OUT17/49619

**Wellington Solar Farm (SSD 8573)
EIS Exhibition**

The department has reviewed the Environmental Impact Statement and provides the following comments and recommendations for consideration in assessment of the proposal. Detailed comments are provided in Attachment A.

Figure 3. Proposal area with development design.

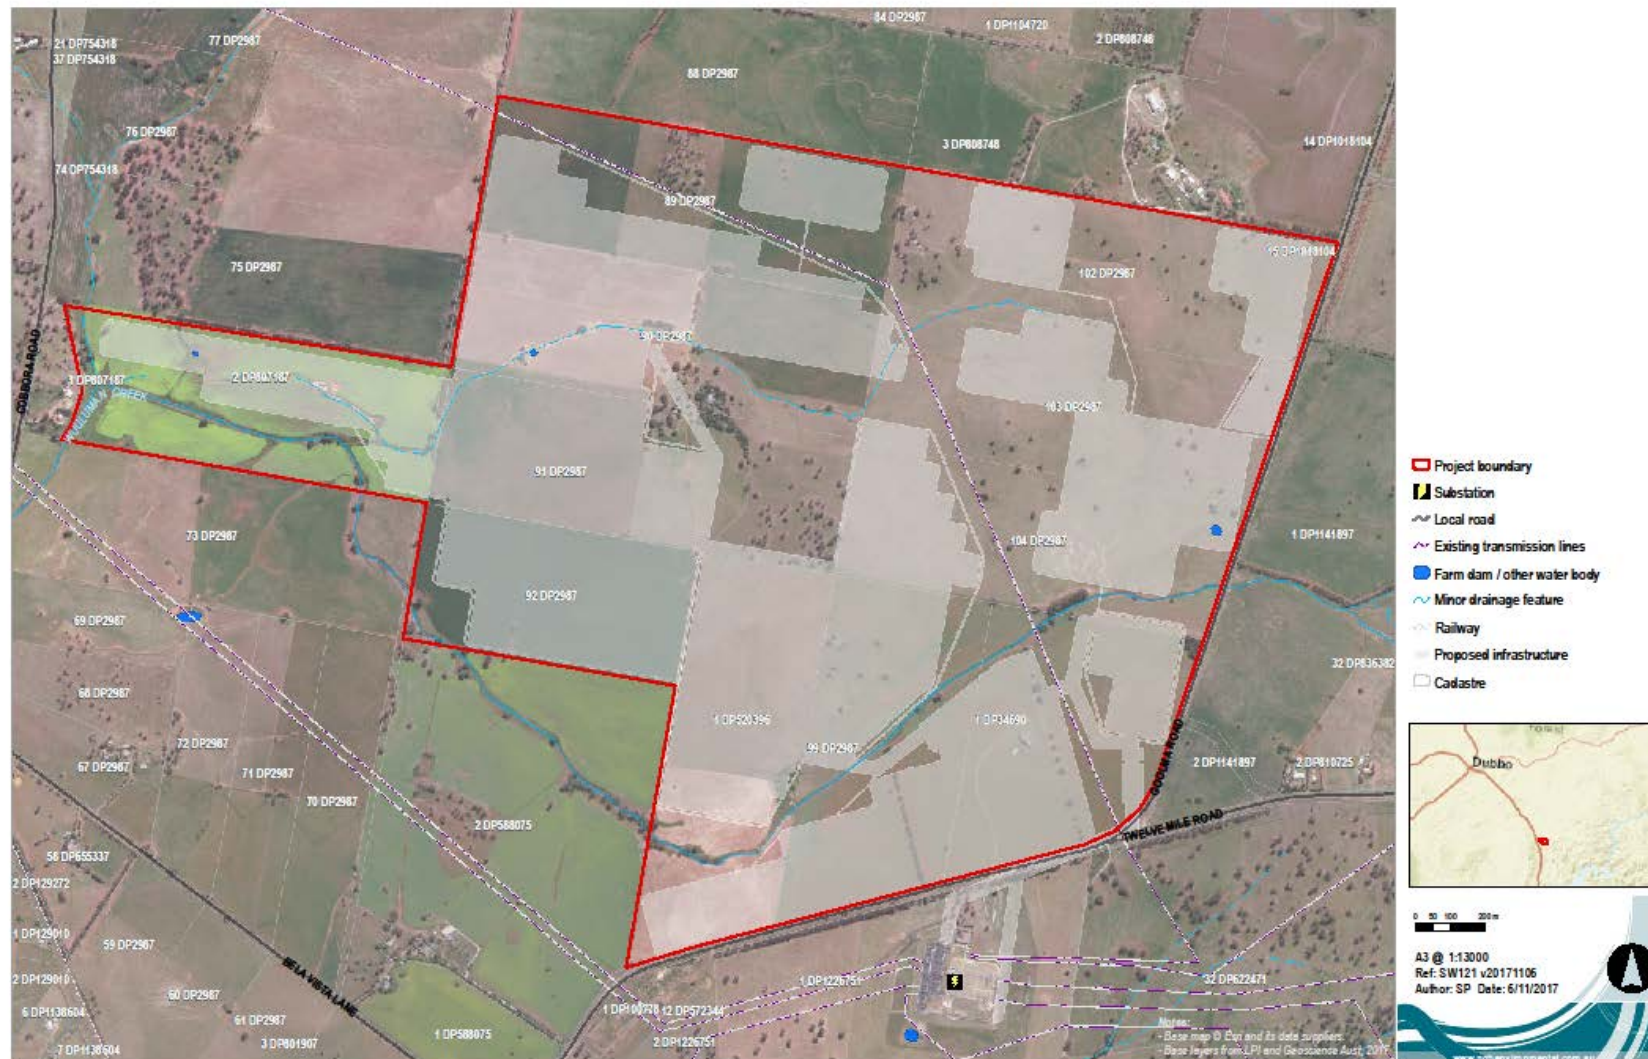
- Reference is made in the EIS to maintaining a 40m buffer from waterways, however it appears from the available plans that roads and other infrastructure (including PV modules and cables) are proposed within the 40m buffer. Buffers should be consistent with the [Guidelines for Controlled Activities on Waterfront Land](#) (DPI 2012).

- All works proposed within waterfront land (40m of the high bank of a watercourse) should be documented on a plan and the buffers should be consistent with the "Guidelines for Controlled Activities on Waterfront Land (DPI 2012)".
